CITY OF ALBUQUERQUE

RE: Carmel Ridge Subdivision
Grading and Drainage Plan
Engineer's Stamp Date 12-16-2016 (File: C20D075)

BEING A REPLAT OF LOT 29, BLOCK 3, UNIT 3, TRACT 2, NAA  
GRADING & DRAINAGE PLAN

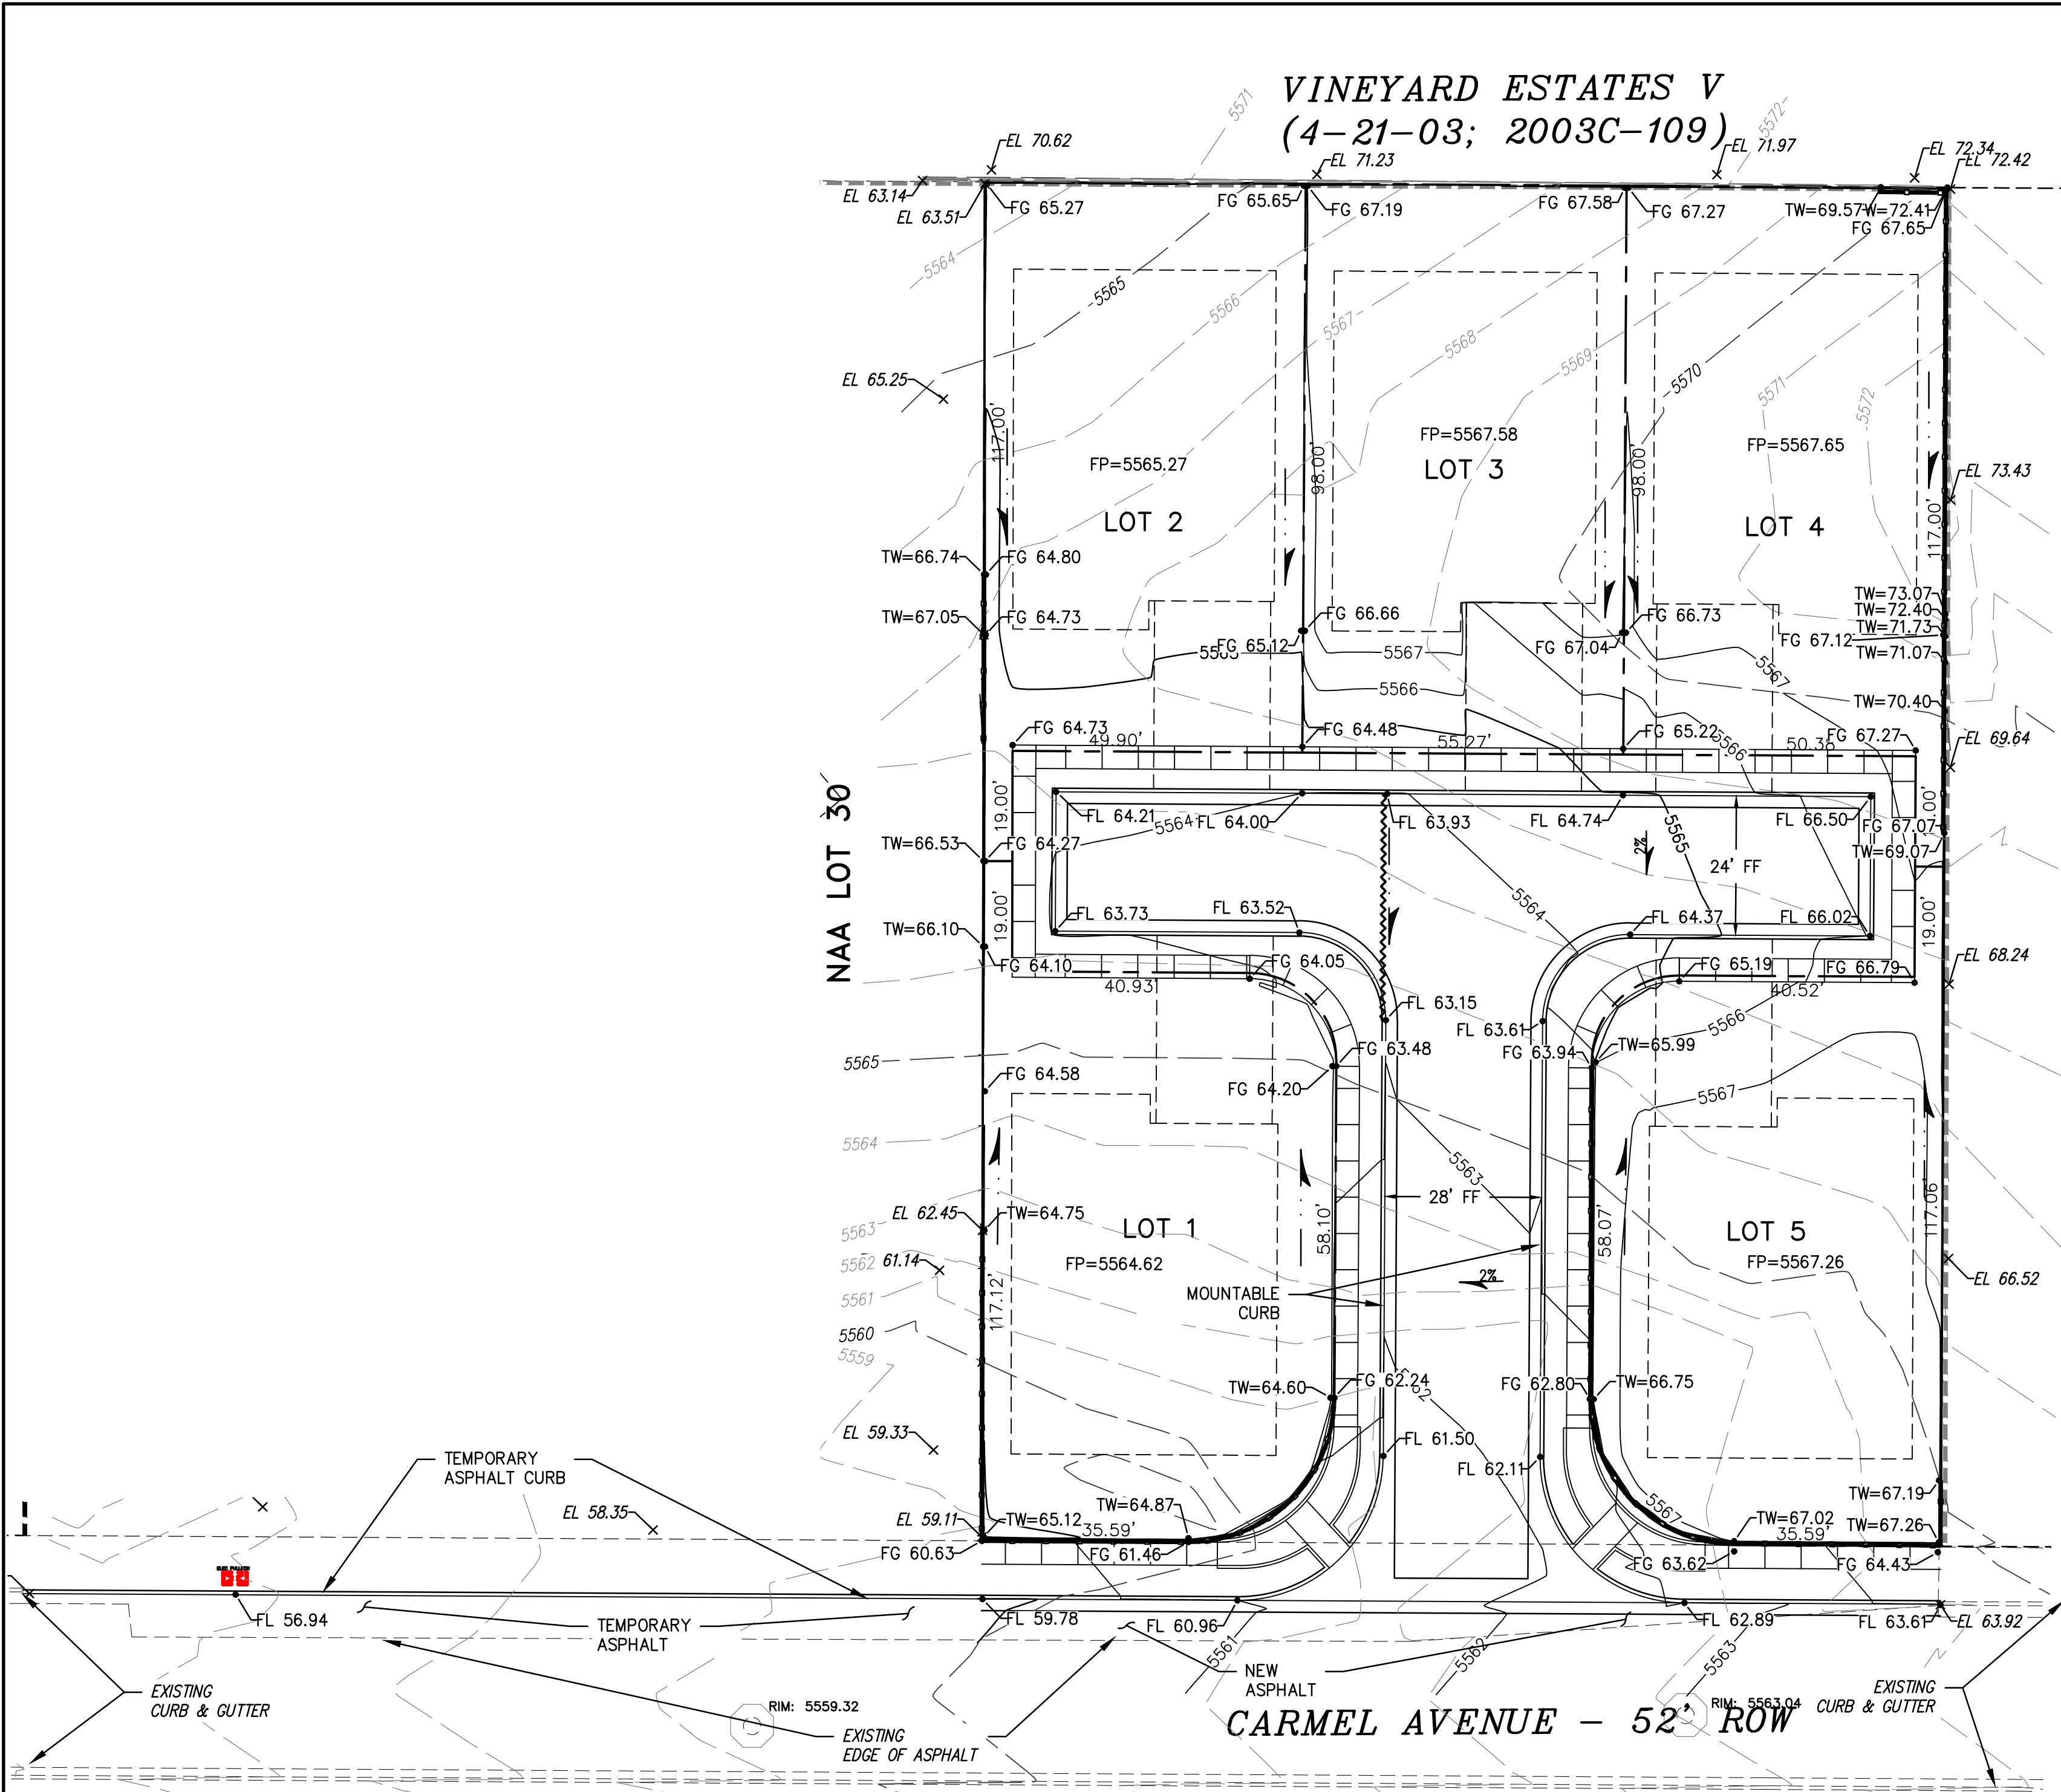
1. Provide a retaining wall on the north of lot 3 and lot 4, where difference between existing and proposed grades is 2 feet or greater.
2. Provide FG grades in the south east area of lot 4. There are TW grades, but no BW/FG grades
3. Please check the grade elevation between the flow line and back of side walk, as it seems to not meet the city standard; curb height plus 2% from top of curb to back of sidewalk.
